Planning Application Ref: BE/63/17/OUT

Location: The Cottage, Shripney Road, Bognor Regis

Description of works: Erection of 21 new houses and flats with access and parking and landscaping.

Consultant Arboriculturist

Fig 2. Proposed Indicative Site Layout Plan

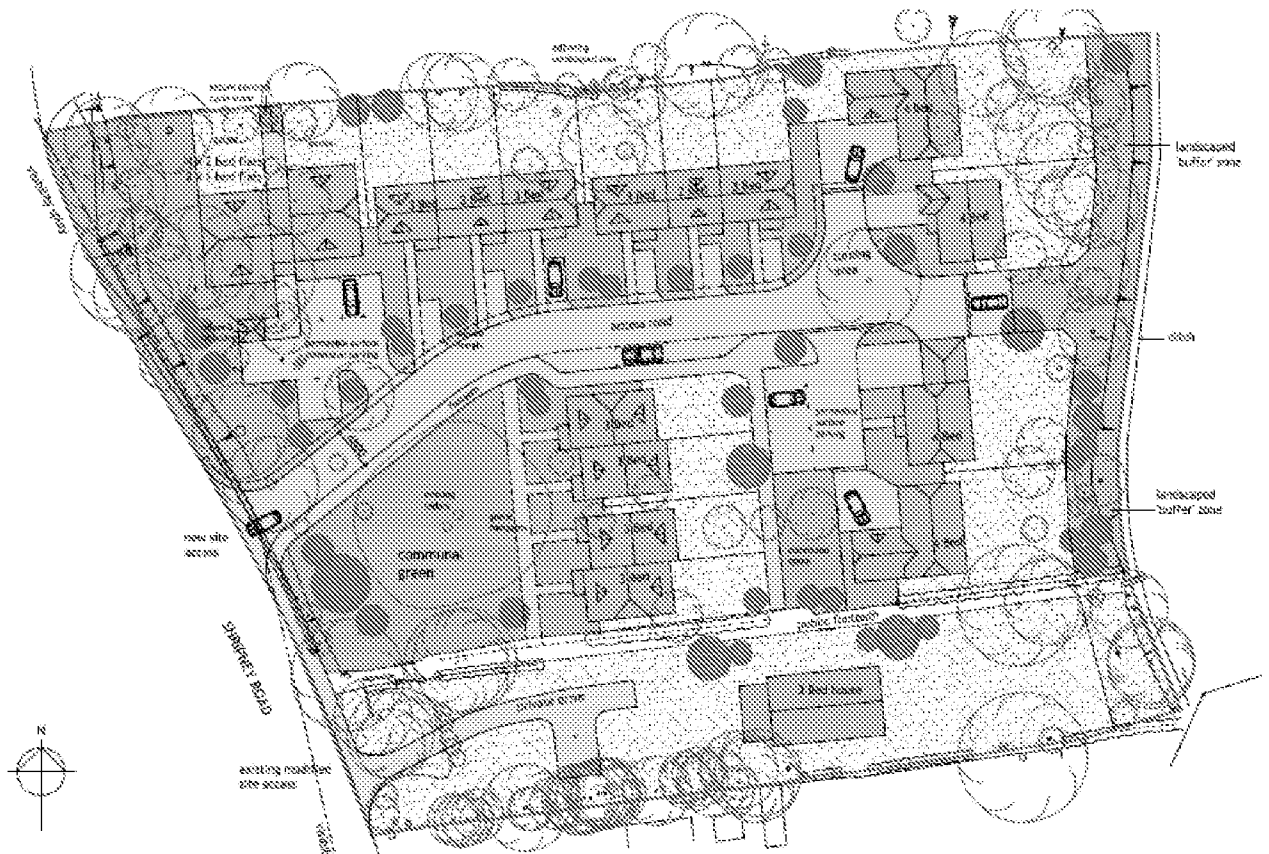
- The very fine mature Ash tree is shown to be removed and there is a risk of root damage to the other trees if this site is not developed in a careful manner in accordance with an AMS report & Tree Protection Plan.

- As things stand I would have to register an **OBJECTION** to this scheme on the grounds that a very fine mature Ash is shown to be removed to facilitate same.
- I would like to see the layout re-designed to accommodate the Ash tree along with the two Cedars and the Oak at the rear with RPA's fully respected.
- The applicants need to employ the services of an Arboricultural Consultant to prepare a supporting **Arboricultural Method Statement Report with Tree Protection Plan** which details how building techniques will be adapted and modified with mitigation measures employed in order that the Ash; Cedars and Oak will be fully respected and not adversely impacted by the building proposals.
- In the interim I strongly recommend that a TPO is made to protect the Ash at the front and the two Cedars and also the Oak at the rear – TEMPO forms are attached as well as a tree location plan.
